PLANNING AND INFRASTRUCTURE
Planning Unit

15 September 2025

Re: State Significant Development Application Number SSD-63324208
Novus - Build to Rent: 410-416 Victoria Avenue, Chatswood
Response to Submissions

PROJECT NOVUS ON VICTORIA 410-416 VICTORIA AVE CHATSWOOD DRAWING TITLE GROUND FLOOR PLAN 1:100@A1

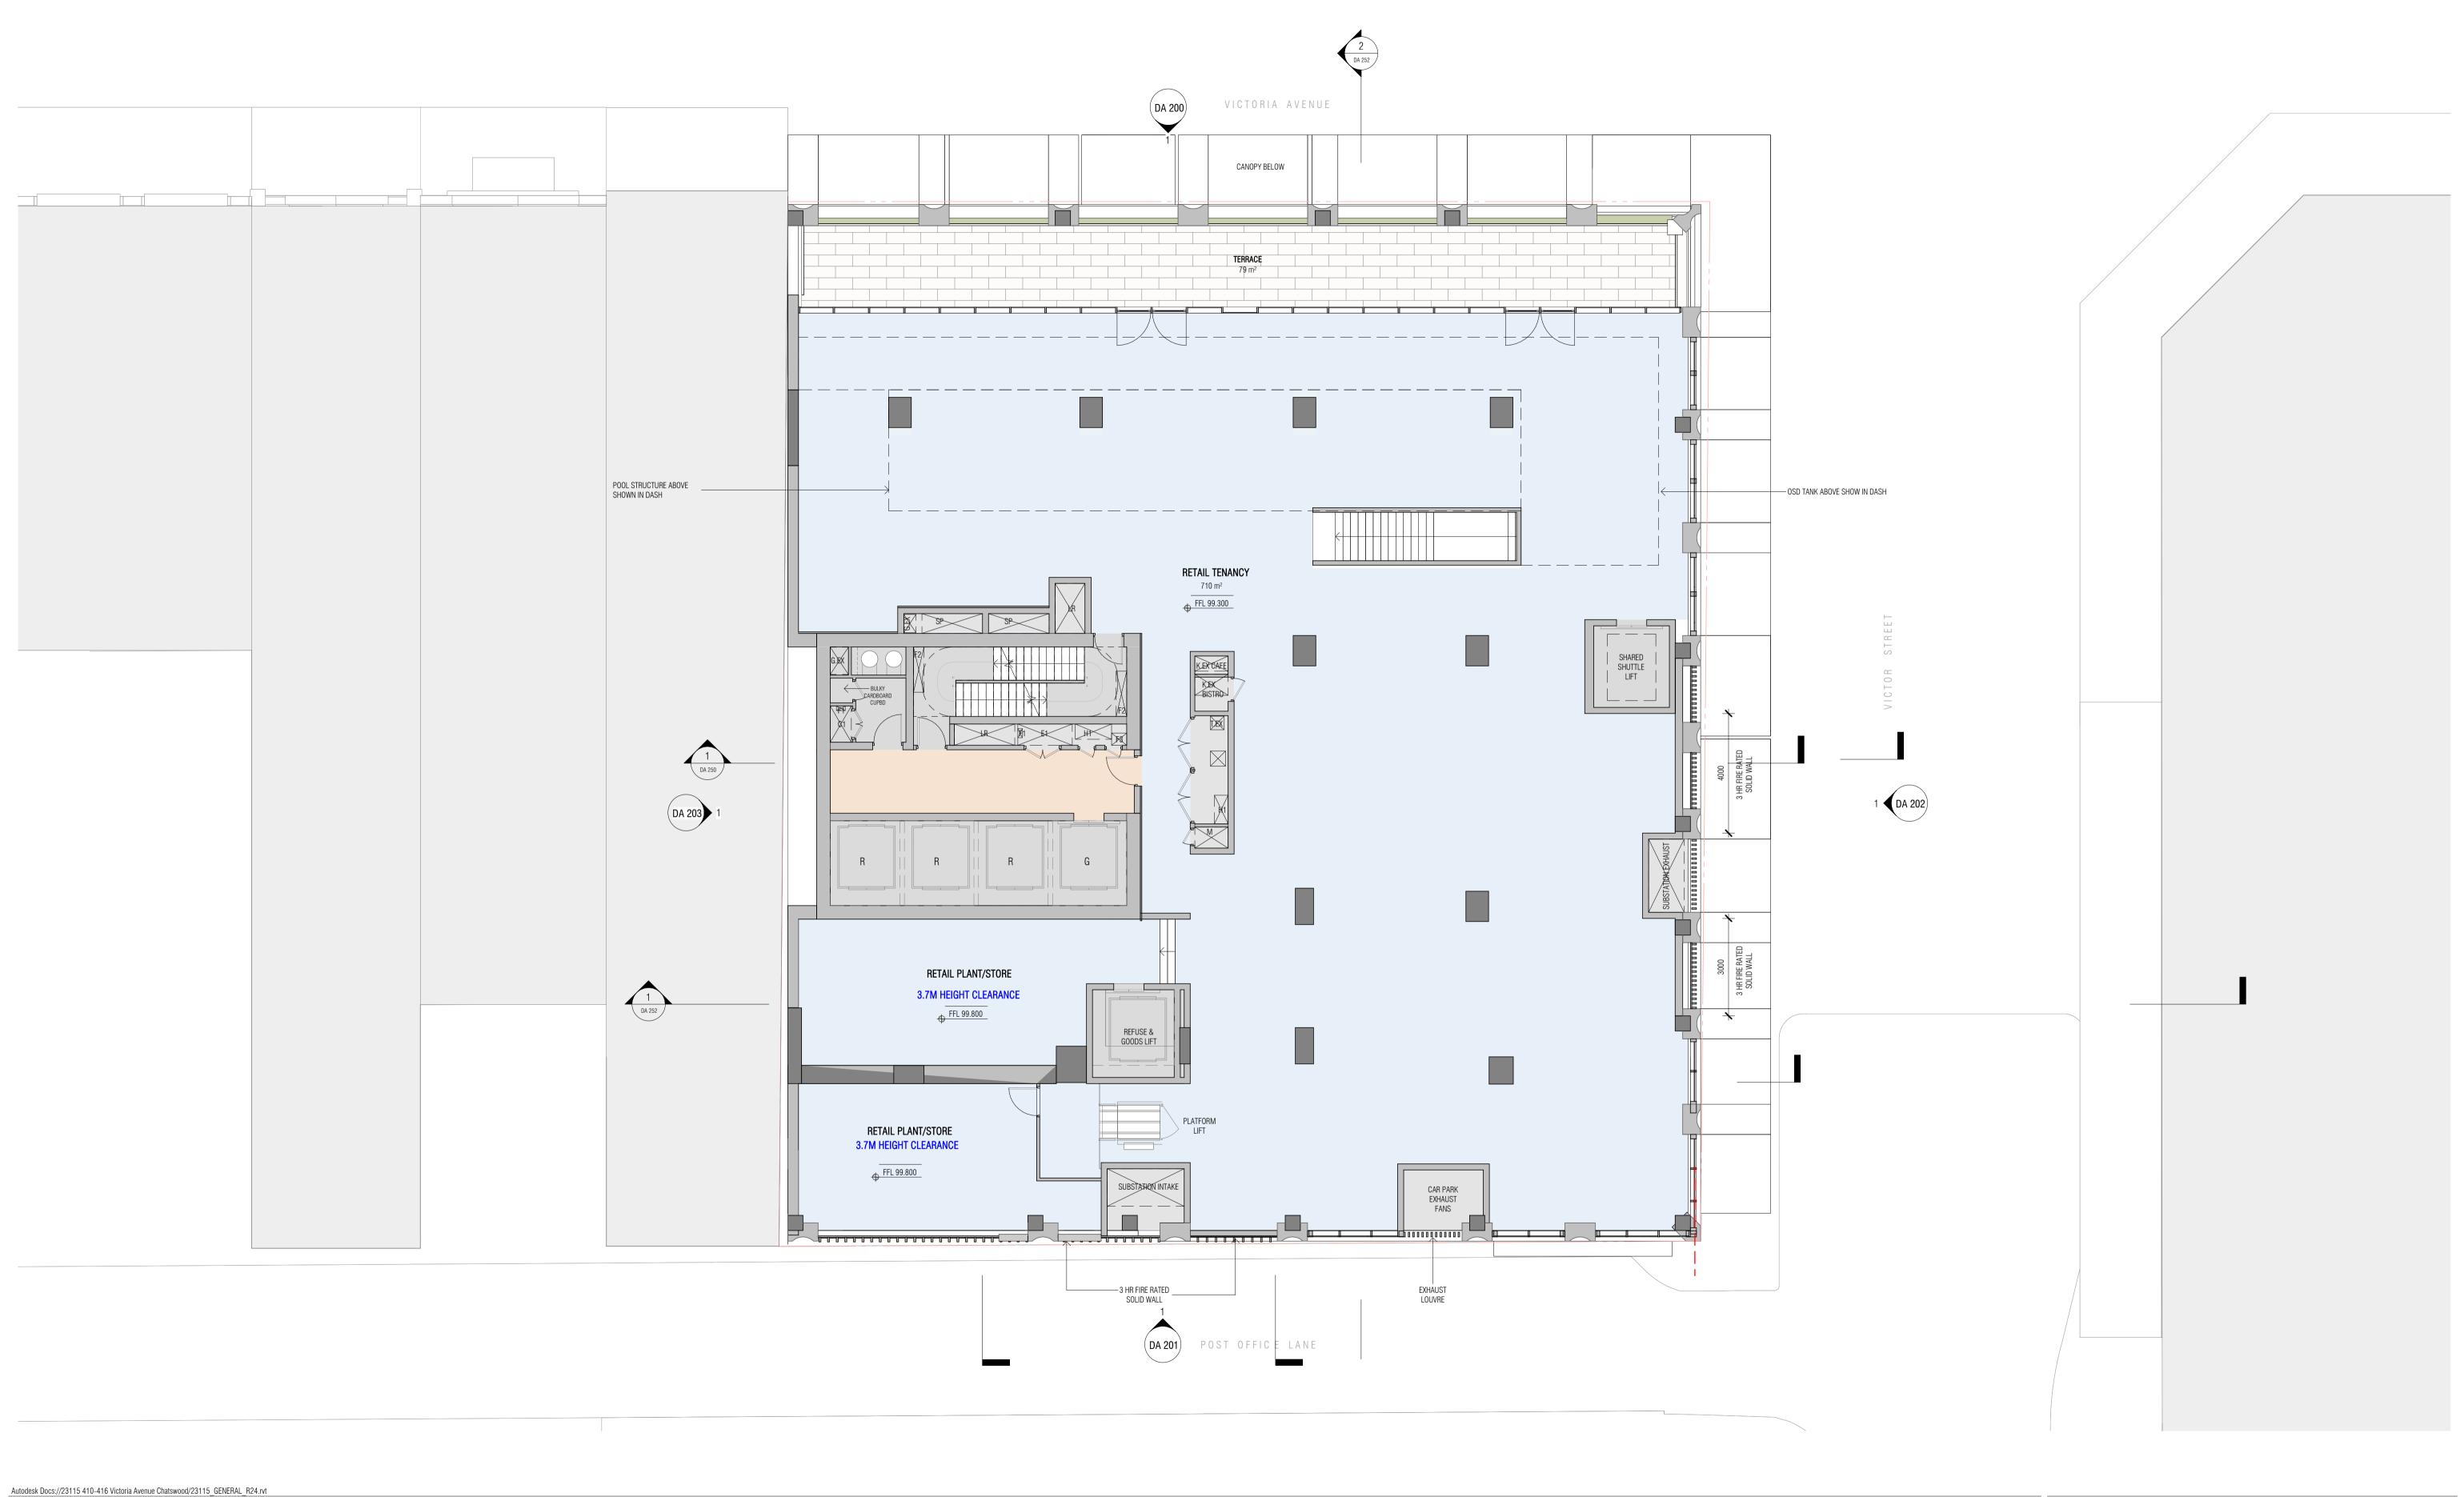
Council acknowledges the proposed relocation of access to the site and agrees that this reduces the impact to Post Office Lane, however it remains insufficiently resolved with respect to its impact on Victor Street. It is also unclear how moving the substation to the ground floor results in “*improved activation at ground floor*”. In the limited time afforded, it is not possible to confirm or verify the purported benefits of the relocation.

Vehicle access has been relocated to Victor Street therefore eliminating previous conflict issues with pedestrian access on Post Office Lane.

The development proposes to engage a private waste contractor, with waste collection occurring from holding area. The waste vehicle is intended to exit via a turntable in a forward direction. However, it has not been demonstrated how this will function in the instance of mechanical failure, nor whether a three point turn is feasible. Council has concerns no clearances have been provided and the close proximity to the accessible parking spaces the turntable is.
